Charlotte Storm Water
600 East Fourth Street
Charlotte, N C 28202-2844

Rezoning Petition Review

Rezoning Petition #: 20-12

Location of Property: Approximately 21.92 acres located on the south side of Eastfield Rd, north of I-485 and west of Browne Rd.

SHEET NUMBER
RZ-1

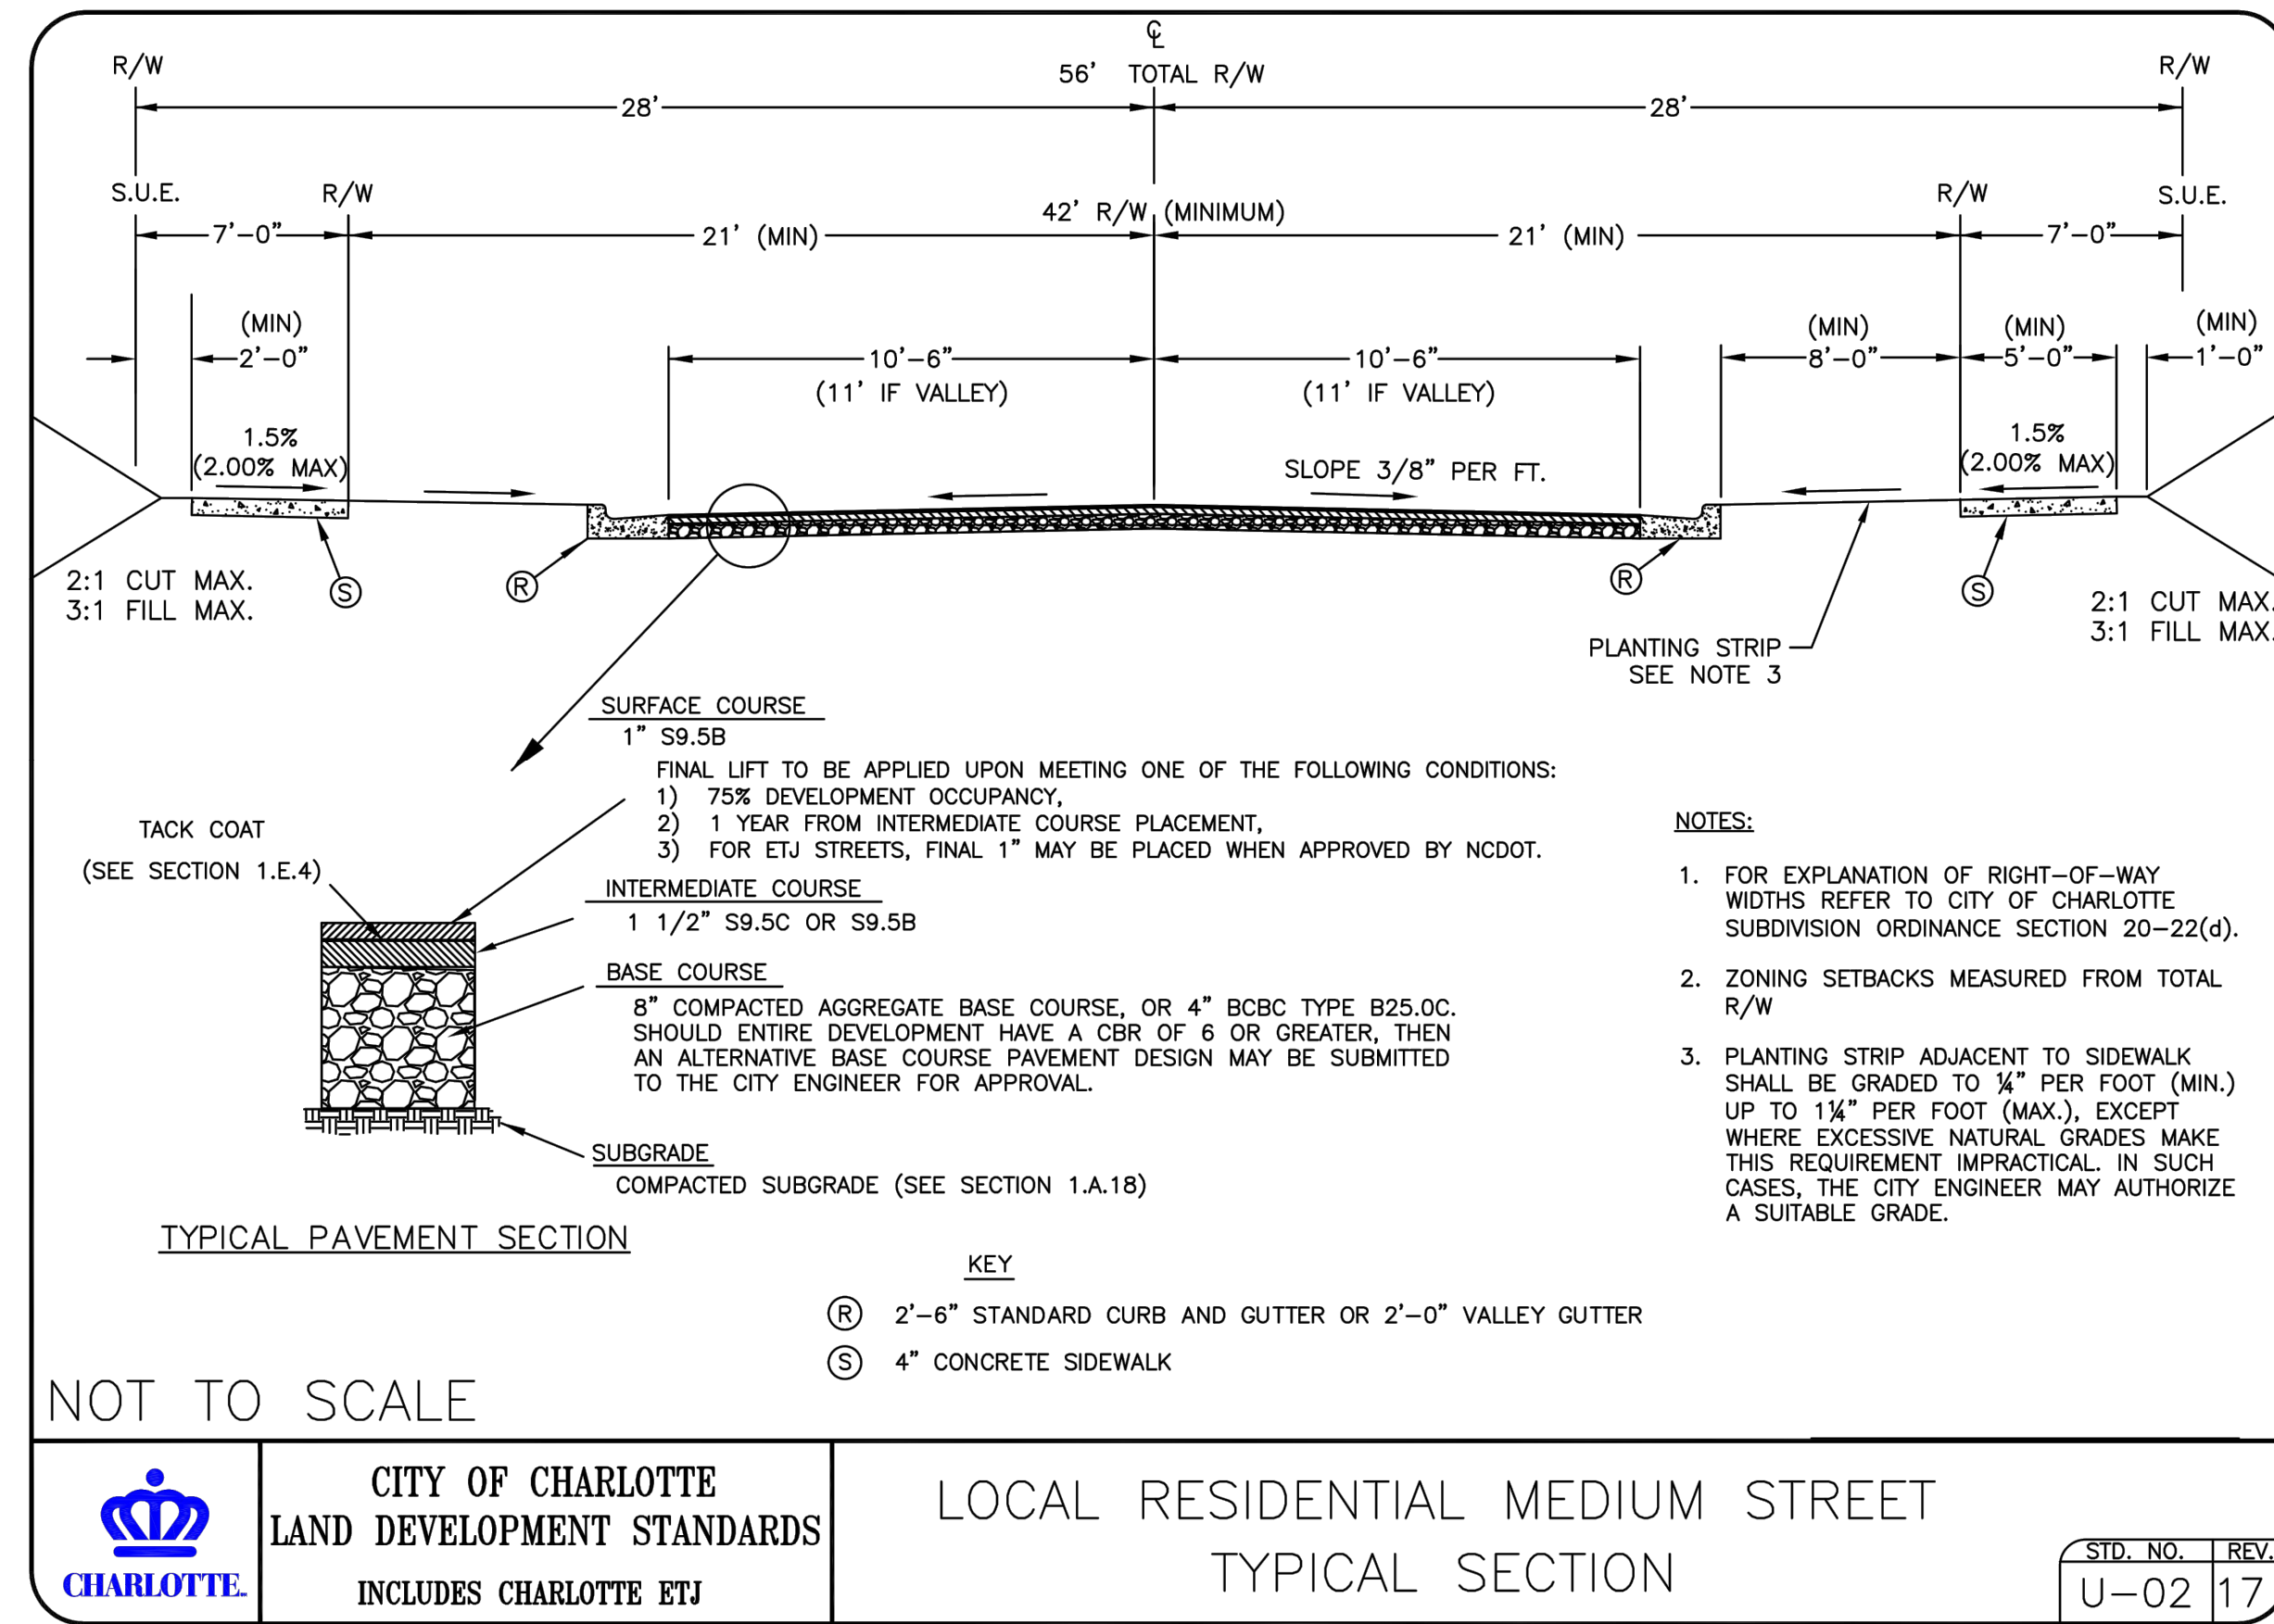
Concerning Storm Water: City of Charlotte GIS data indicates a 100-ft Undisturbed PCSO buffer across the site. Please show and label *Potential 100-ft Undisturbed PCSO Buffer* on the site plan. Any increase of impervious area within such buffers may not be allowed and is not approved with the rezoning process. Stream Delineation Reports are subject to review and approval by Charlotte Storm Water Services. Please include the following note under Environmental Features: *"Development within any SWIM/PCSO Buffer shall be coordinated with and subject to approval by Charlotte-Mecklenburg Storm Water Services and mitigated if required by City ordinance."*

The proposed rezoning plan sheet indicates a proposed location for storm water management. Please include the following notes on the plan sheet under Environmental Features: *The location, size, and type of storm water management systems depicted on the Rezoning Plan are subject to review and approval as part of the full development plan submittal and are not implicitly approved with this rezoning. Adjustments may be necessary in order to accommodate actual storm water treatment requirements and natural site discharge points.*
